# City of Albuquerque Stormwater Construction Site Inspection Report

ECS File No.	P09E002D CV	Project Name:	Ceja Vista Unit 1
NPDES Id. No.	NMR100ZBE	Location:	9800 Dsennis Chavez SW
12/29/2020	Dennis Chavez	Contractor	
Operator	Ceja Vista LLC	Franklins	
Contact name & title	Bill Allen manager	Gus Harbaugh	
e-mail	ballen@westpacnm.com	Gus.Harbaugh@feinm.com	
Contact Phone #	505-440-7262	w796-5457 m975-2864	
COA Inspector	Doug Hughes	Start/End Time:	8am
Construction Phase:	infrastructure complete		
Type of Inspection:	Regular	Storm Event	Post Storm Event >0.25"
		311/Complaint	Follow Up
Weather at time of inspection?		Cloudy	Temperature: ~ 40
Estimated date of last storm 0.25" or greater		12/11/2020

RECEIVING WATERS: UNNAMED POND	
CRITICAL HABITAT: CRITERION "A"; NO CRITICAL HABITATS WITHIN PROJECT AREA	
GPS LOCATION: 35.0235, -106.7402	
CEJA VISTA	
PROJECT TITLE	
ALBUQUERQUE, BERNALILLO COUNTY, NM	
CITY, COUNTY, STATE	
07/29/2019	DATE
C. DURKIN	DRAWN BY

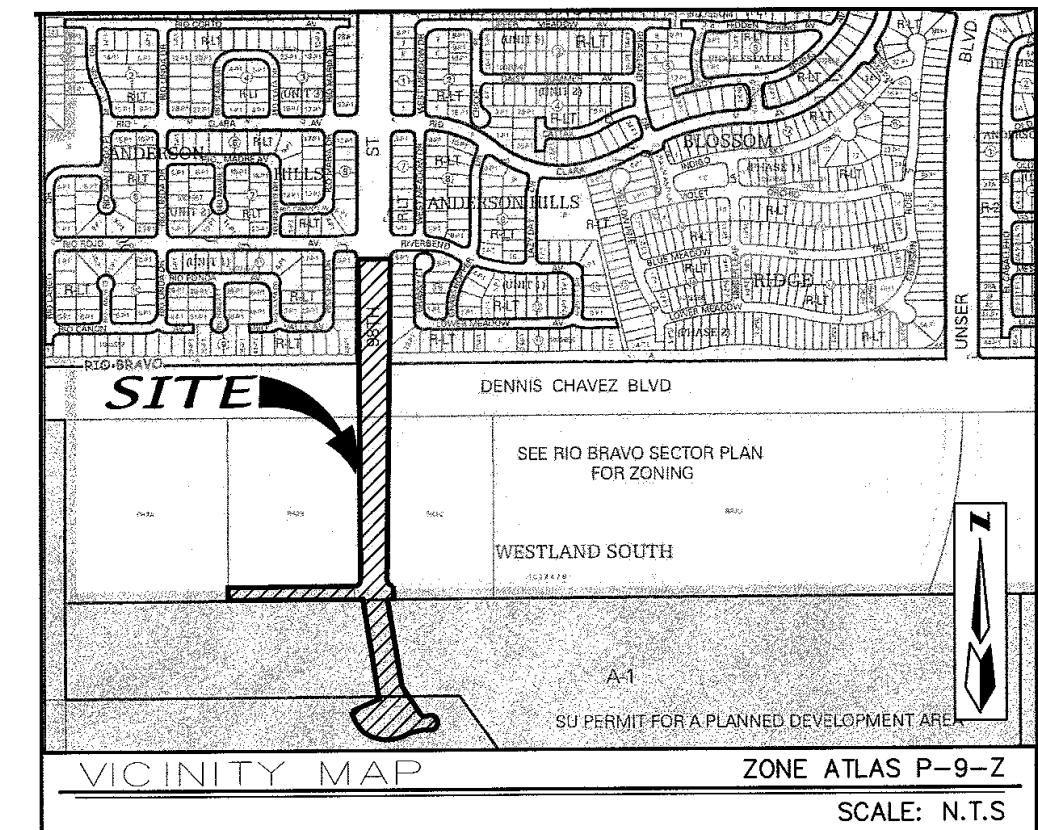
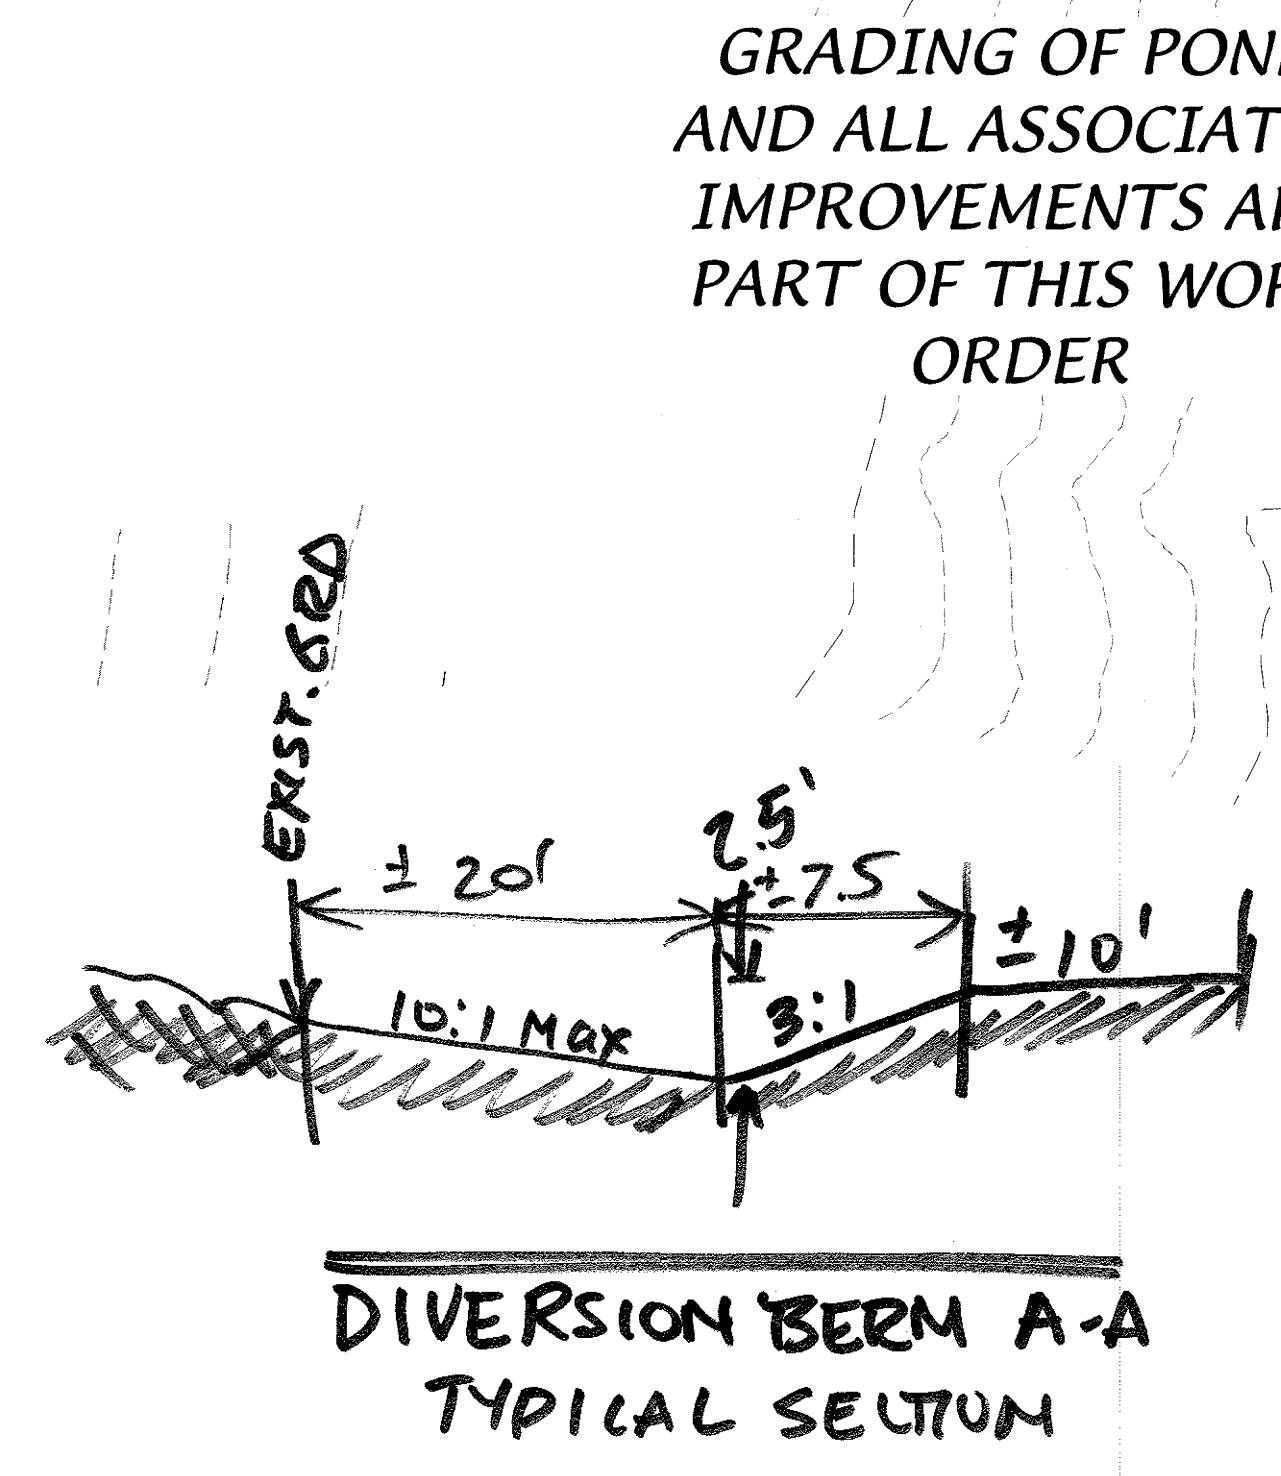
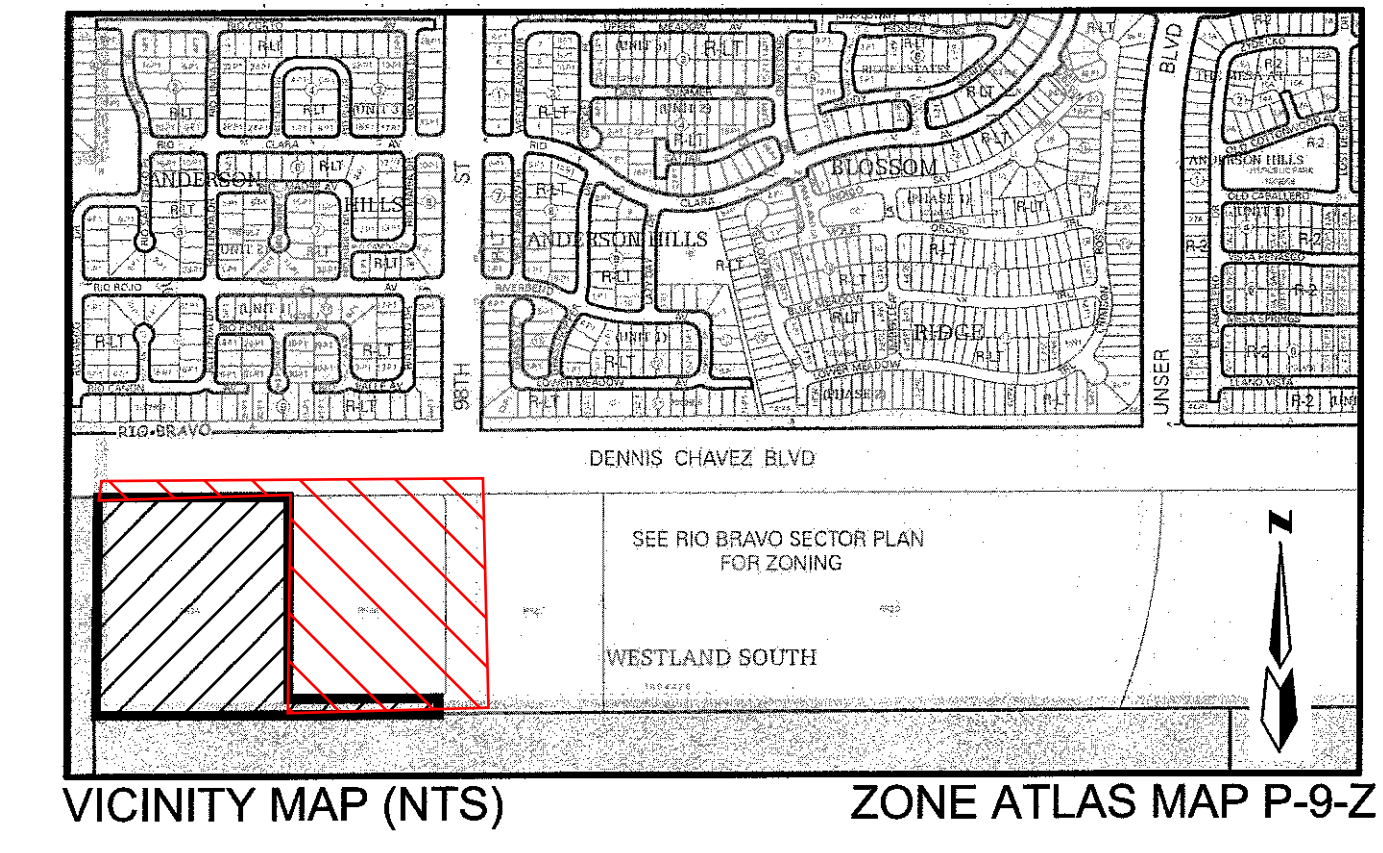
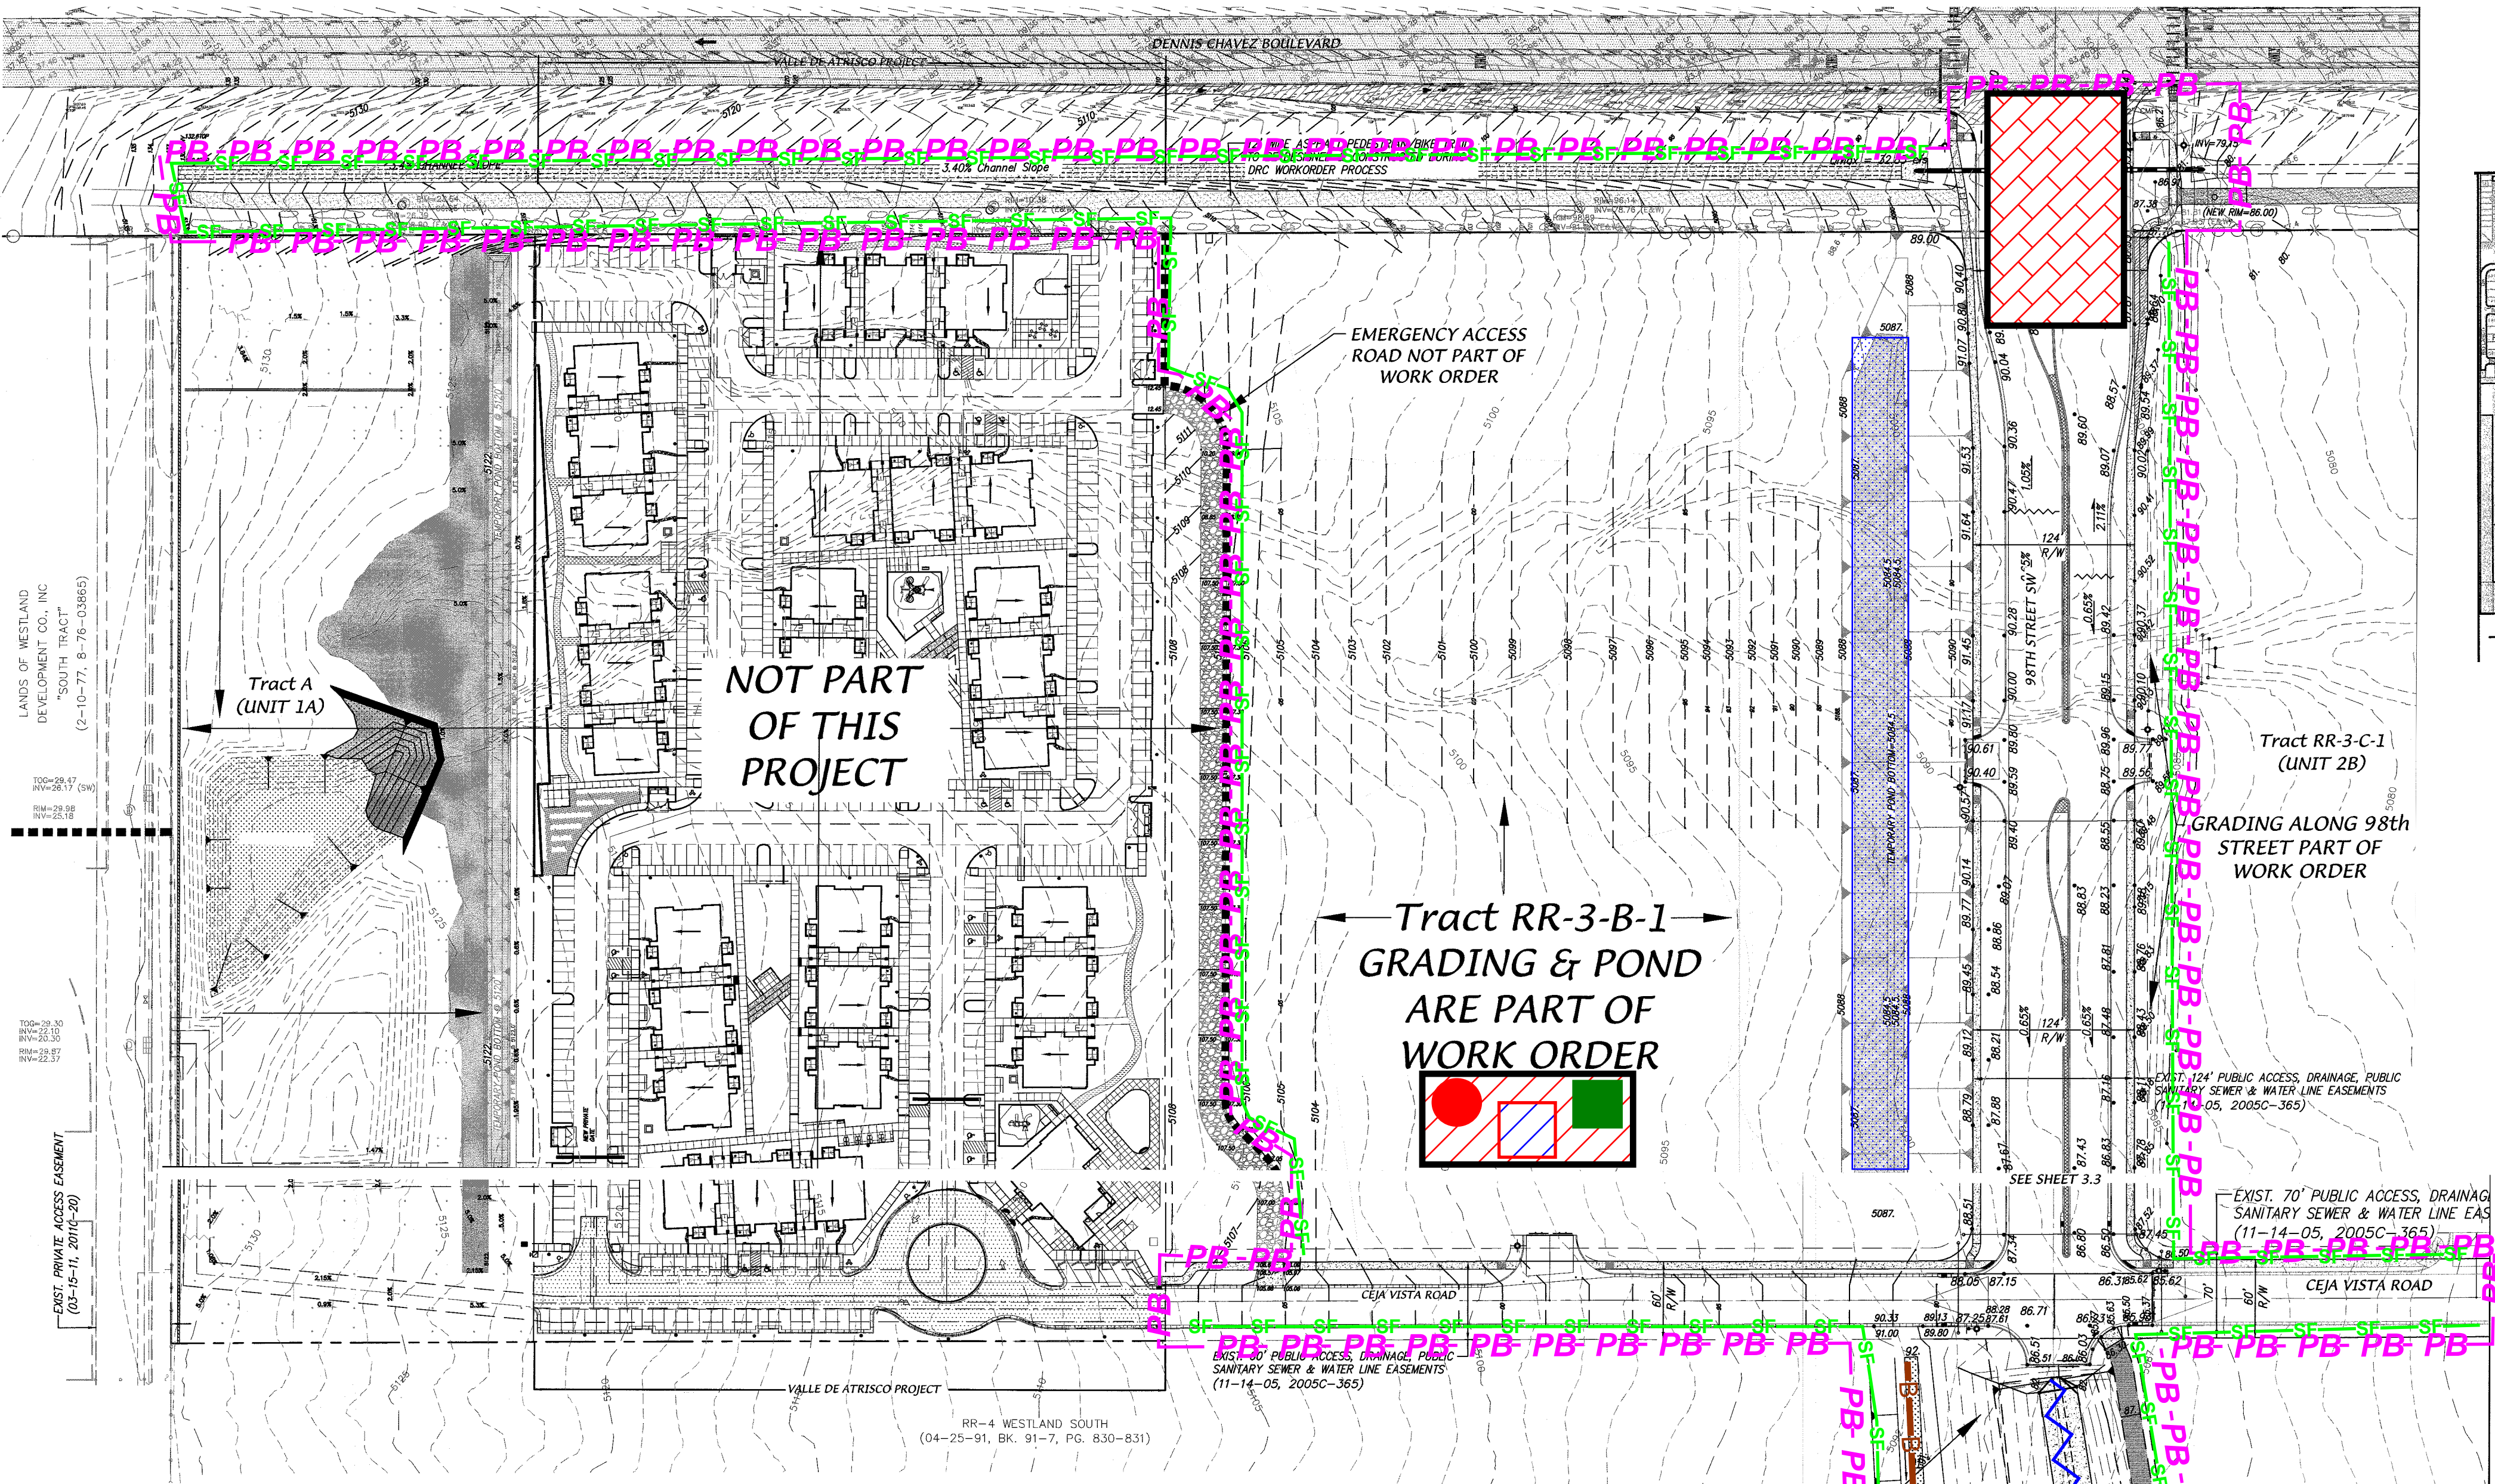
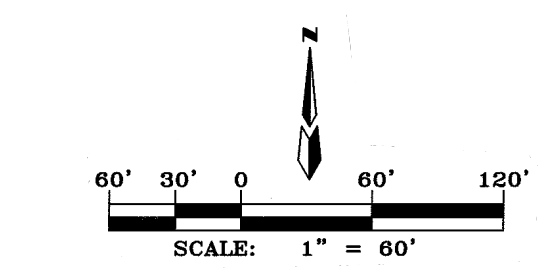
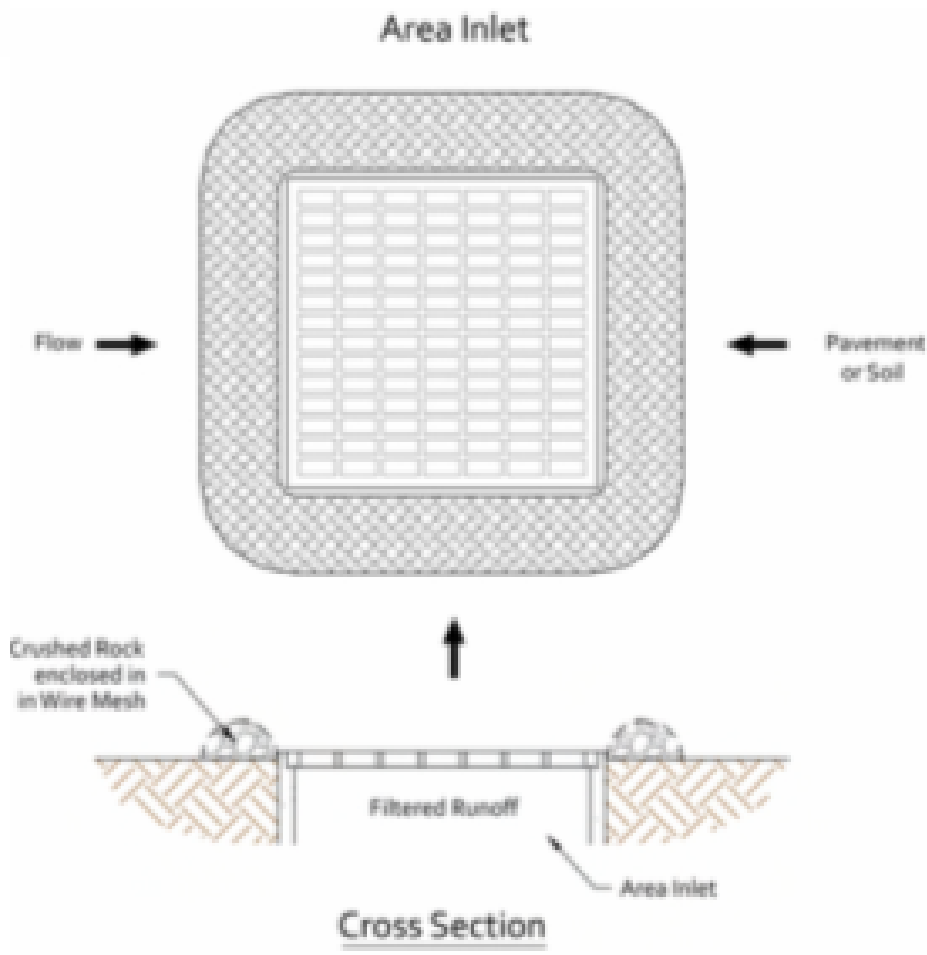
Item Number	Deficiency/ Corrective Action		
1	Silt fence down and full of sediment reset all and add more along Dennis Chaves		
2	Remove sediment from street and sidewalk.		
3	Stabilize all disturbed areas		
4	Provide self inspection reports
